City of Portland, Maine - Building or Use Permit Application
389 Congress Street, 04101 Tel: (207) 874-8703, Fax: (207) 874-8716

Permit No: 03-1341	Issue Date: NOV 19 2003	CBL: 169 A035001
-----------------------	-----------------------------------	---------------------

Location of Construction: 35 Providence St	Owner Name: Plourde Mark	Owner Address: 29 Providence St CITY OF PORTLAND	Phone: 207-228-5043
Business Name: n/a	Contractor Name: Jim White	Contractor Address: 2 Farwell Court Westbrook	Phone: 2078783361
Lessee/Buyer's Name: n/a	Phone: n/a	Permit Type: Single Family	Zone: R5

Past Use: Vacant	Proposed Use: Build New 26' x 32' Single Family Home, no garage & no deck.	Permit Fee: \$987.00	Cost of Work: \$98,750.00	CEO District: 2
----------------------------	--	--------------------------------	-------------------------------------	---------------------------

APPROVED BY: [Signature]
REVISOR: S-0200 SITE SURVEY

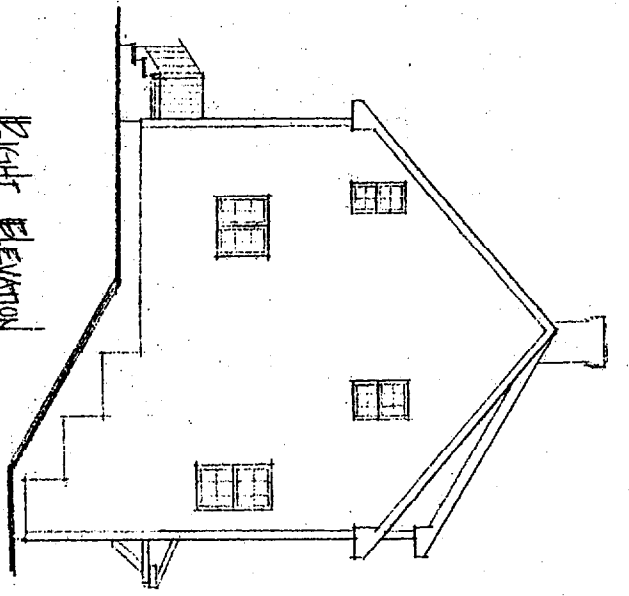
Dept: Zoning	Status: Approved with Conditions	Reviewer: Marge Schmuckal	Approval Date: 11/06/2003
Note:			Ok to Issue: <input checked="" type="checkbox"/>
<ol style="list-style-type: none"> 1) Shall first demolish the existing garage which is straddling the newly proposed property line. 2) There is a rear daylight basement shown on the plans. A daylight basement is approved with this permit 3) Separate permits shall be required for future decks, sheds, pools, and/or garages. No rear nor side decks shown on plans, therefore, none are approved or permitted. 4) This permit is being approved on the basis of plans submitted. Any deviations shall require a separate approval before starting that work.

FOUNDATION PLAN
SCALE: 1/4"=1'-0"

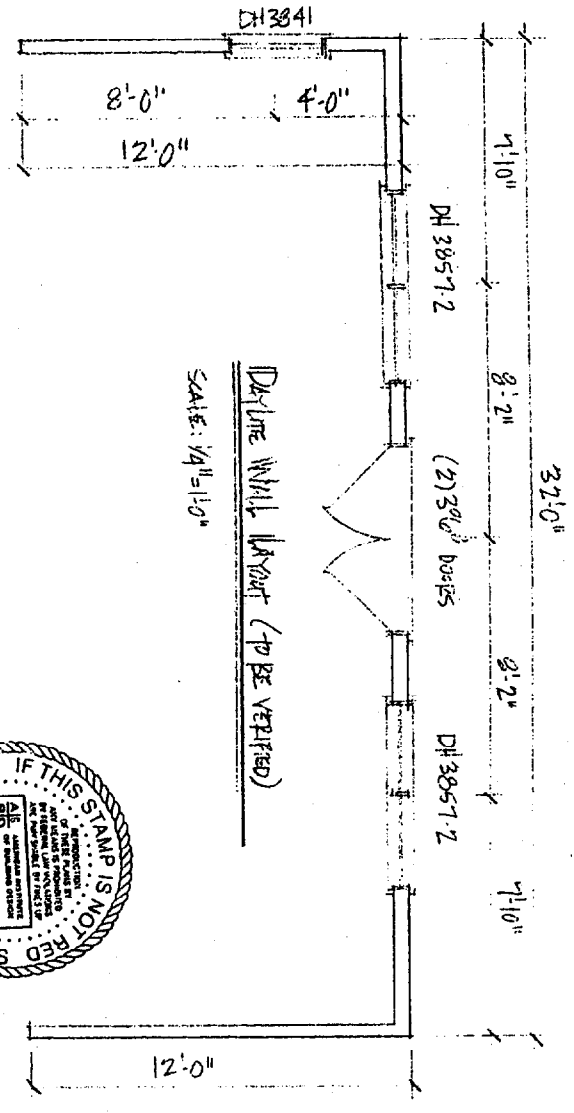
Soil type/Presumptive Load Value (Table 401.4.1)	Clay/sand	
STRUCTURAL Footings Dimensions/Depth (Table 403.1.1 & 403.1.1(1), Section 403.1.2)	8" x 16" Footing	
Foundation Drainage Dampproofing (Section 406)	Drains ? dampproof - filter	OK
Ventilation (Section 409.1) Crawls Space ONLY	Daylight	
Anchor Bolts/Straps (Section 403.1.4)	? spacing • verify bolt	OK
Lally Column Type, Spacing and footing sizes (Table 502.3.4(2))	Lally 3 1/2"	
Built-Up Wood Center Girder Dimension/Type (Table 502.3.4(2))	3-2x12, 5 1/4 x 1 1/4 Paralamin 10'3" span 1 st Floor 2 nd Floor same	max span 10'0" 9'4" will increase to 4-2x12 OK
Sill/Band Joist Type & Dimensions	2x6 PT 2x10	
First Floor Joist Species Dimensions and Spacing (Table 503.3.1(1) & Table 503.3.2(1))	2x10 16" O.C.

- 1) Exterior surface of foundation walls below finish grade will be treated with a bituminous coating.
- 2) Drainpipes around exterior footings to be covered with filter fabric.
- 3) Foundation anchor bolts spaced at 6' o. c. and 12" from corners.
- 4) Increase size of girder beam below kitchen to (4) 2x12's.
- 5) Framing connections per Boca fastening schedule Table 2305.2.
- 6) Headroom clearance at stairs to be minimum 6'-8" finish.
- 7) Half walls, rails balusters to be installed per BOCA 1014.7 and 1021.0.
- 8) Chimney to have 2" air space and metal flashing at all floors and roof.
- 9) Smoke detectors to be installed in all bedrooms and at every level. Detectors to be hardwired in series with battery backup.
- 10) Front step to be built with 2x8 pressure treated framing supported by min. 8" diameter concrete sonotubes.
